From: Anita Gardner
Sent: 23 October 2017 18:55
To: Planning.Responses
Subject: FW: Planning application Ancton Manor

Please scan against M/32/17/L and M/31/17/PL as correspondence between agent and historic building adviser

From: Andrew Fuller [REDACTED]
Sent: 12 October 2017 12:28
To: Anita Gardner
Cc: Estella Wood
Subject: RE: Planning application Ancton Manor

Job Title			
Client	Ancton Manor Dr Heather Beaumont		
Drawing Name	Plans & Elevations Proposed		
Drawing Status	Planning		
Drawn by	AF	Date	Mach 17
Checked by		Date	
Drawing Scale	1:100 at A2		
Drawing No	16905/ 02	Status	Revision
			A

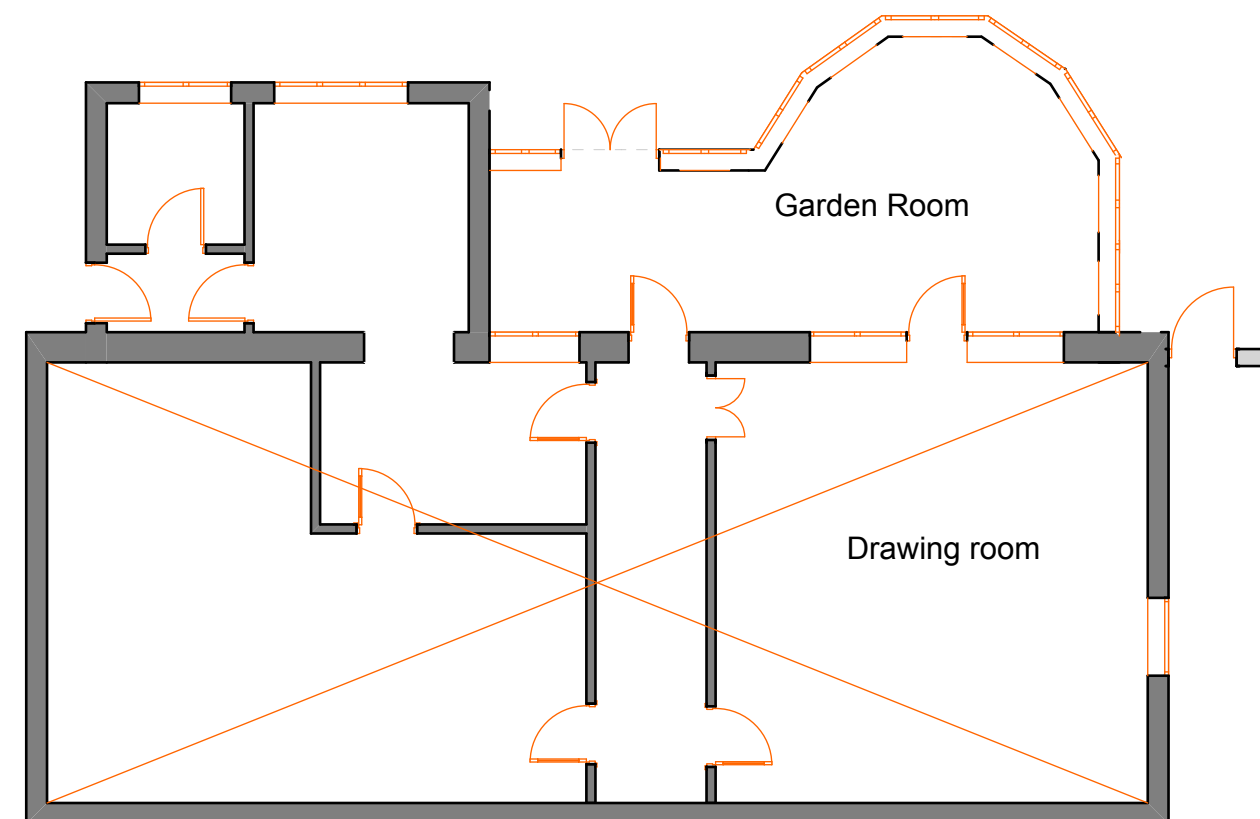
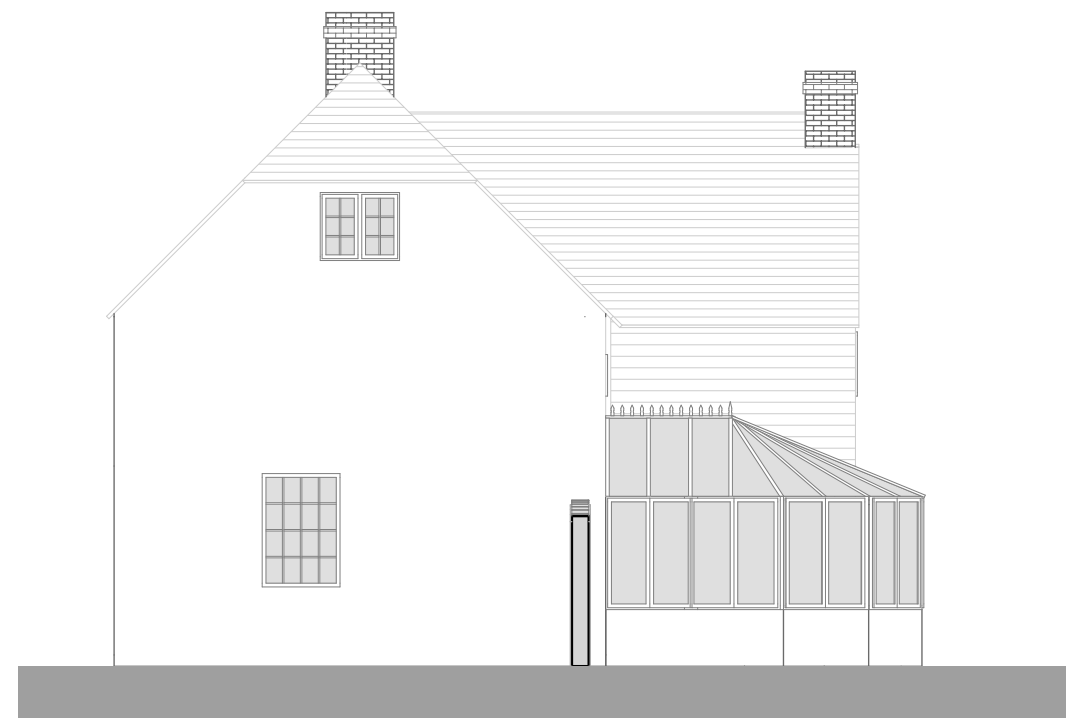
Thank you for your drawings and apologies for the delay getting back to you. This seems a more sympathetic approach as long as the finished article does not appear too barn-like with the heavy timbers. Yes, I agree that the building without a parapet is more sympathetic.

As discussed on the phone reservations remain regarding the use of a crown roof. Whilst we appreciate that they limit the impact of a full roof and provide a sense of vernacular form, they are a bit of a hybrid and very much a modern artifice. In this instance we believe it also introduces a little too much bulk and weight to the building.

Looking at this further we wonder whether the main part of the extension which projects furthest should be considered more as a separate element from the shallower addition. This could then be connected to the remainder of the building with a simpler leaded roof. This would break up the overall form, but also make it appear lighter.

I attach also the drawing as submitted, which shows the omission of the parapet design, and the timber frame with suggested roof.
